Cobalt Geosciences, LLC
P.O. Box 82243
Kenmore, Washington 98028

December 6, 2021

**RE: Geotechnical Letter
Proposed Two Lot Subdivision**
4001 W. Mercer Way
Mercer Island, Washington

In accordance with your authorization, Cobalt Geosciences, LLC has prepared a plan review letter following receipt of a site plan showing the planned building location. We understand that the City of Mercer Island is requesting that we comment on code item 19.09.090 A-2 c i-iii.

SHEET CONTENT  
**SITE PLAN**

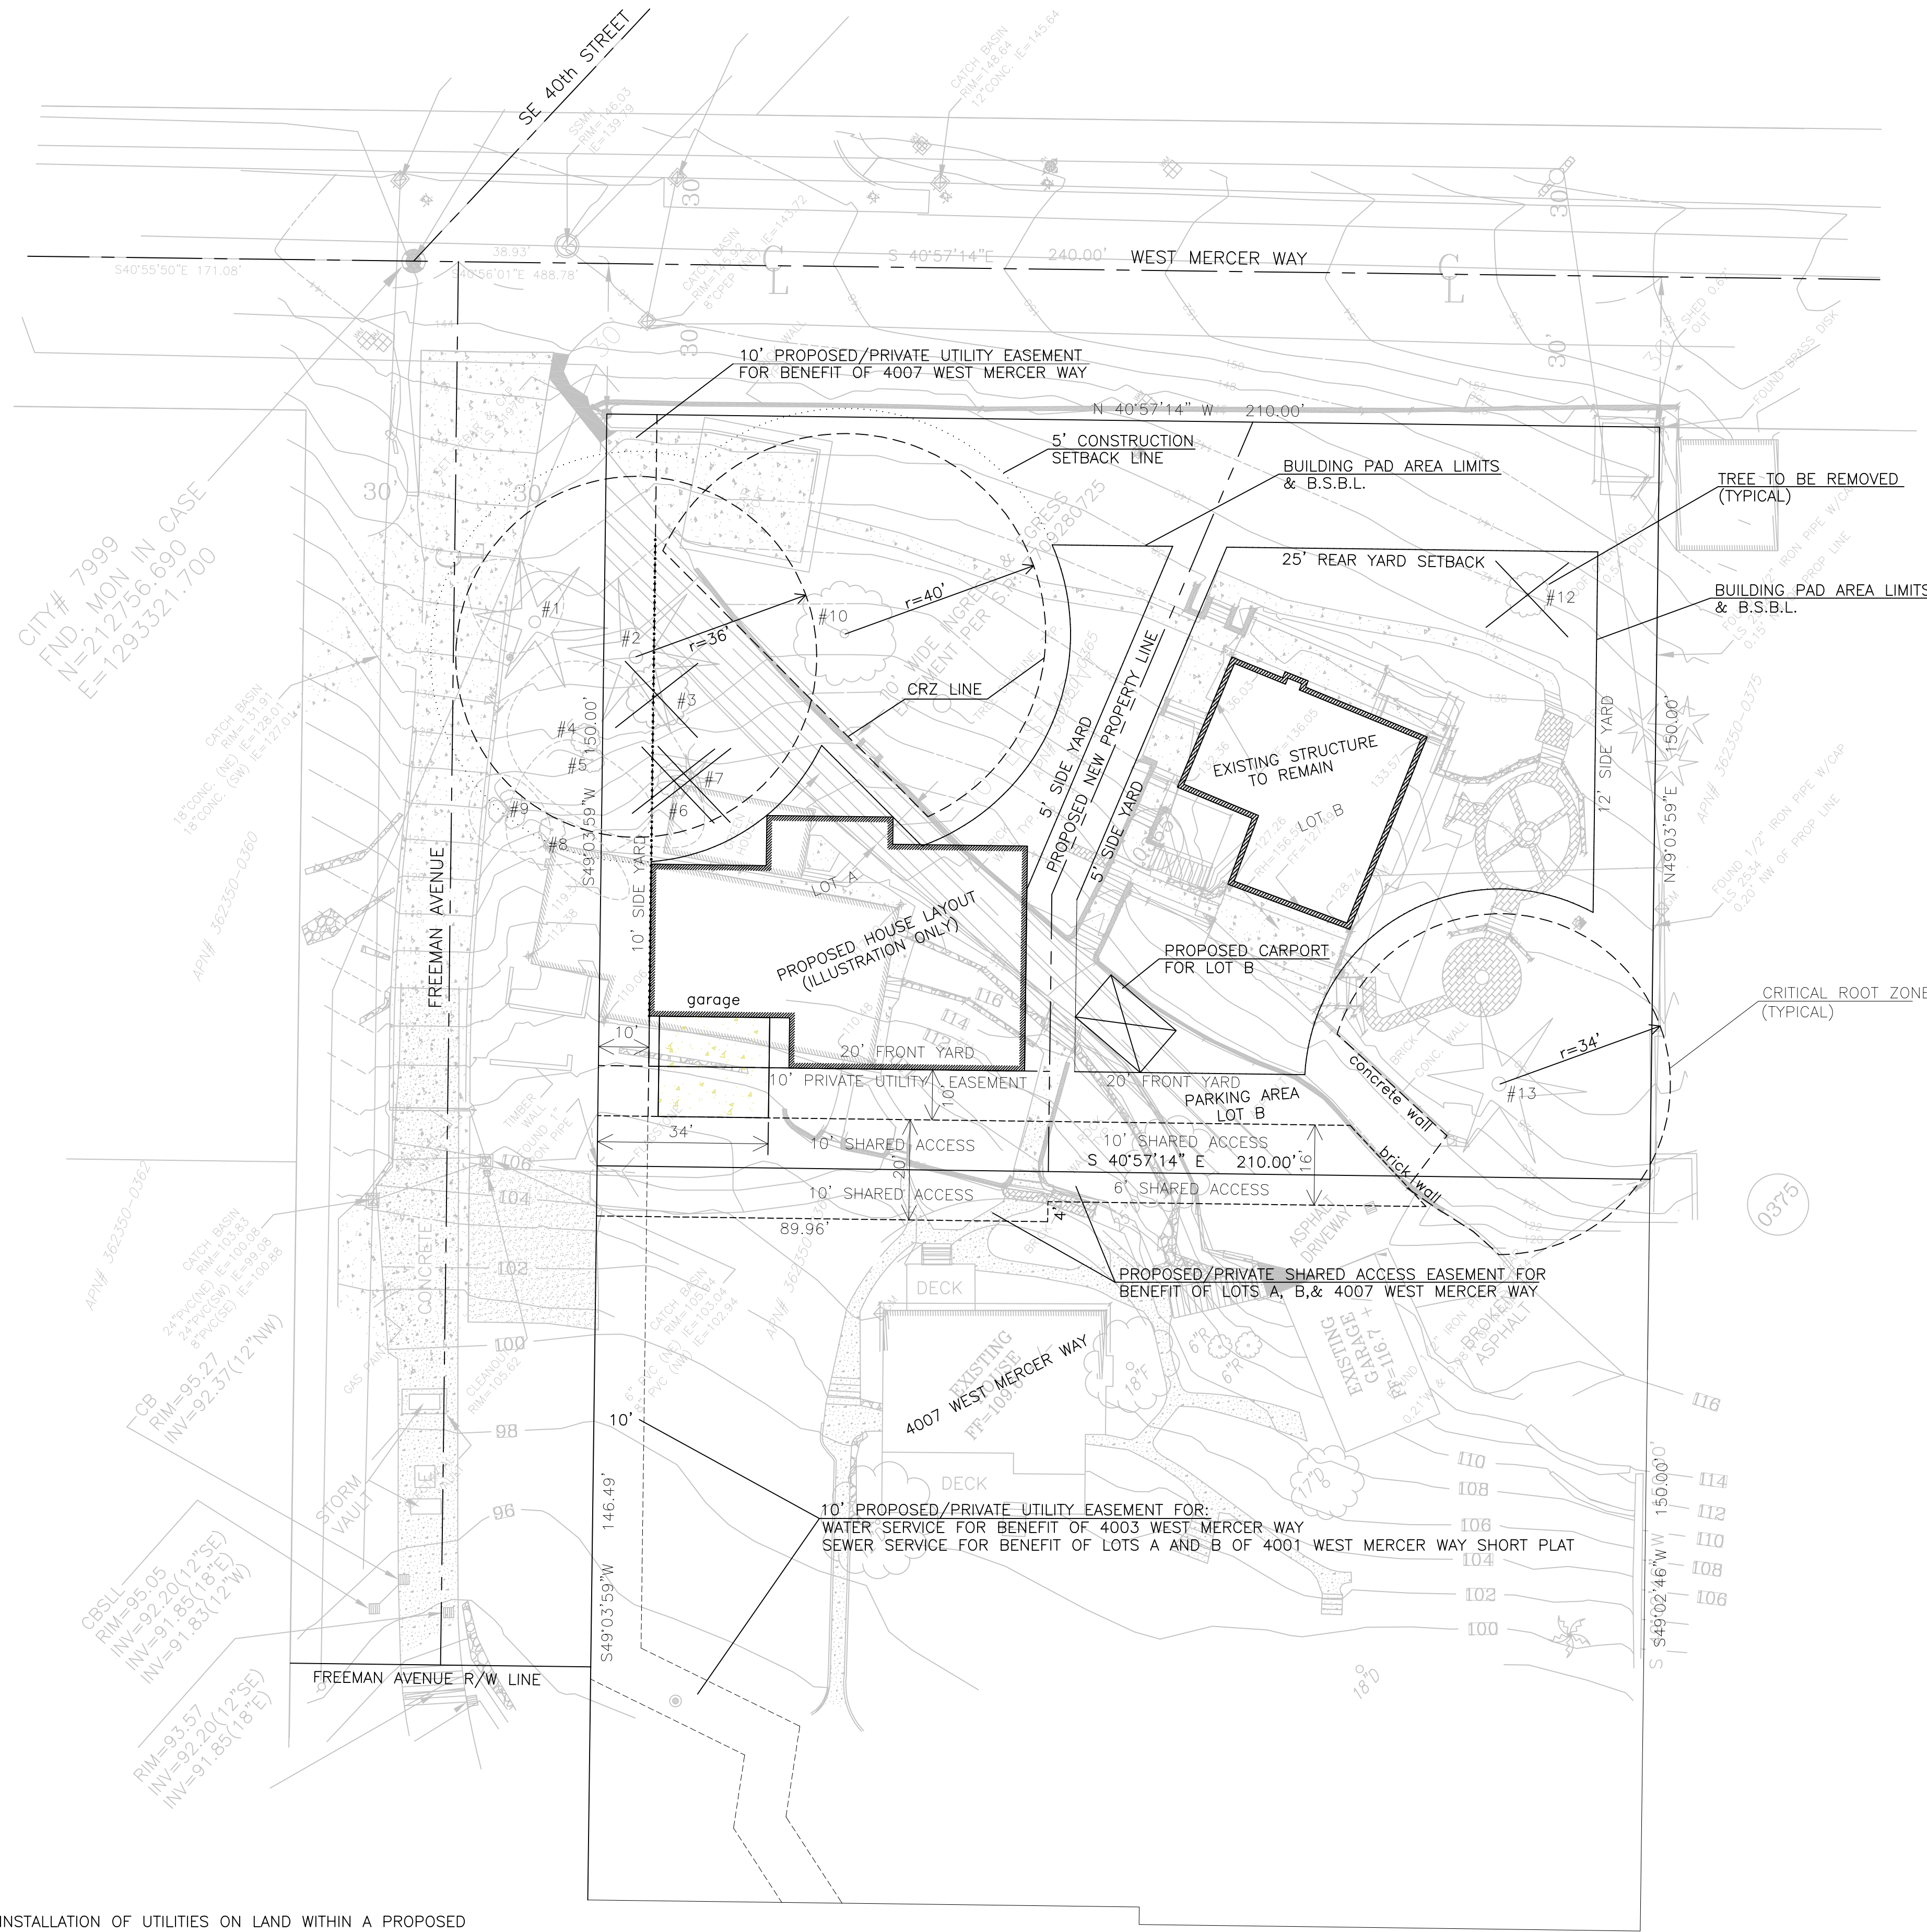
It is our opinion that the criteria referenced in (i) has been satisfied. The building pad location appears suitable and appears to minimize impacts to nearby sloped areas and hazard zones (ii). The building is not within a steep slope area and is at least 10 feet from steeper slope areas (iii). Additionally, the site soils are relatively dense and resistant to instability.
